**KIRKLEES METROPOLITAN COUNCIL
INVESTMENT & REGENERATION SERVICE**

**DELEGATED DECISION FOR APPLICATION FOR CERTIFICATE OF
LAWFUL DEVELOPMENT**

Reference no.: 2025/CL/91752/W

Site: 7, Lynton Avenue, Springwood, Huddersfield, HD1
4EX

BUILDING DESIGN SERVICES M. FAROOQ 418 Bury Road Rochdale OL11 5EU. Tel: 01706 712231 Mob: 07967605763		
PROPOSED REAR DORMER EXTENSION AT 7 LYNTON AVENUE HUDDERSFIELD HD1 4EX		
for: Mr MOHAMMED DANYAAL ISHAIQ		
Section	Scale 1:50	A 2308 /3
Elevation	Scale 1:100

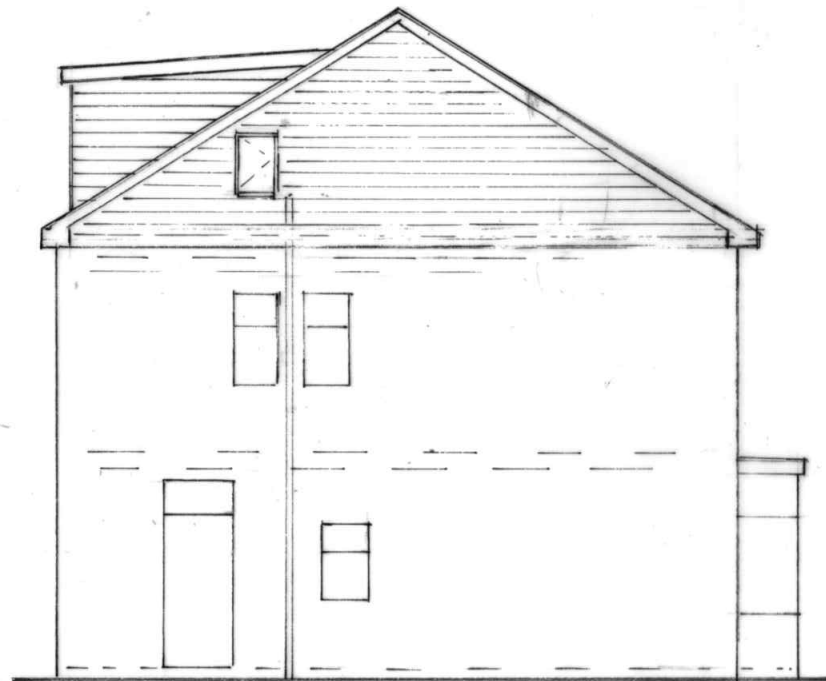
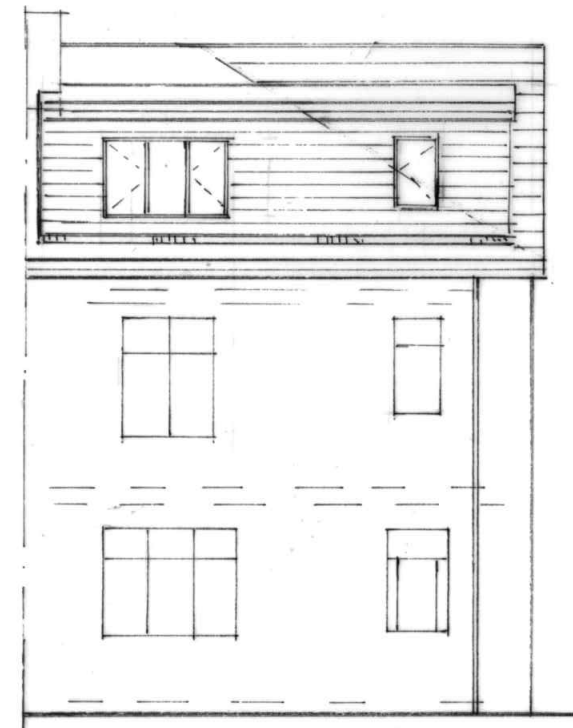
Comment: *The construction materials for the hip to gable enlargement would need be of similar appearance to those used in the construction of the existing dwellinghouse to meet the criteria of the condition. A window is proposed within the side elevation roof slope of the hip to gable extension. The window would*

need to be obscurely glazed and non-opening to meet the criteria of this condition.

Comment: *The submitted details imply that the roof lights would not protrude above the roof slope. Provided that the alteration would not protrude more than 0.15 metres beyond the plane of the roof slope then this criteria would be met.*

Comment: The proposed roof lights would not be located on the side elevation of the roof slope.

NOTE: Condition B.2(c) states : (c) any window inserted on a wall or roof slope forming a side elevation of the dwellinghouse must be –

- (i) obscure-glazed, and
- (ii) non-opening unless the parts of the window which can be opened are more than 1.7 metres above the floor of the room in which the window is installed.
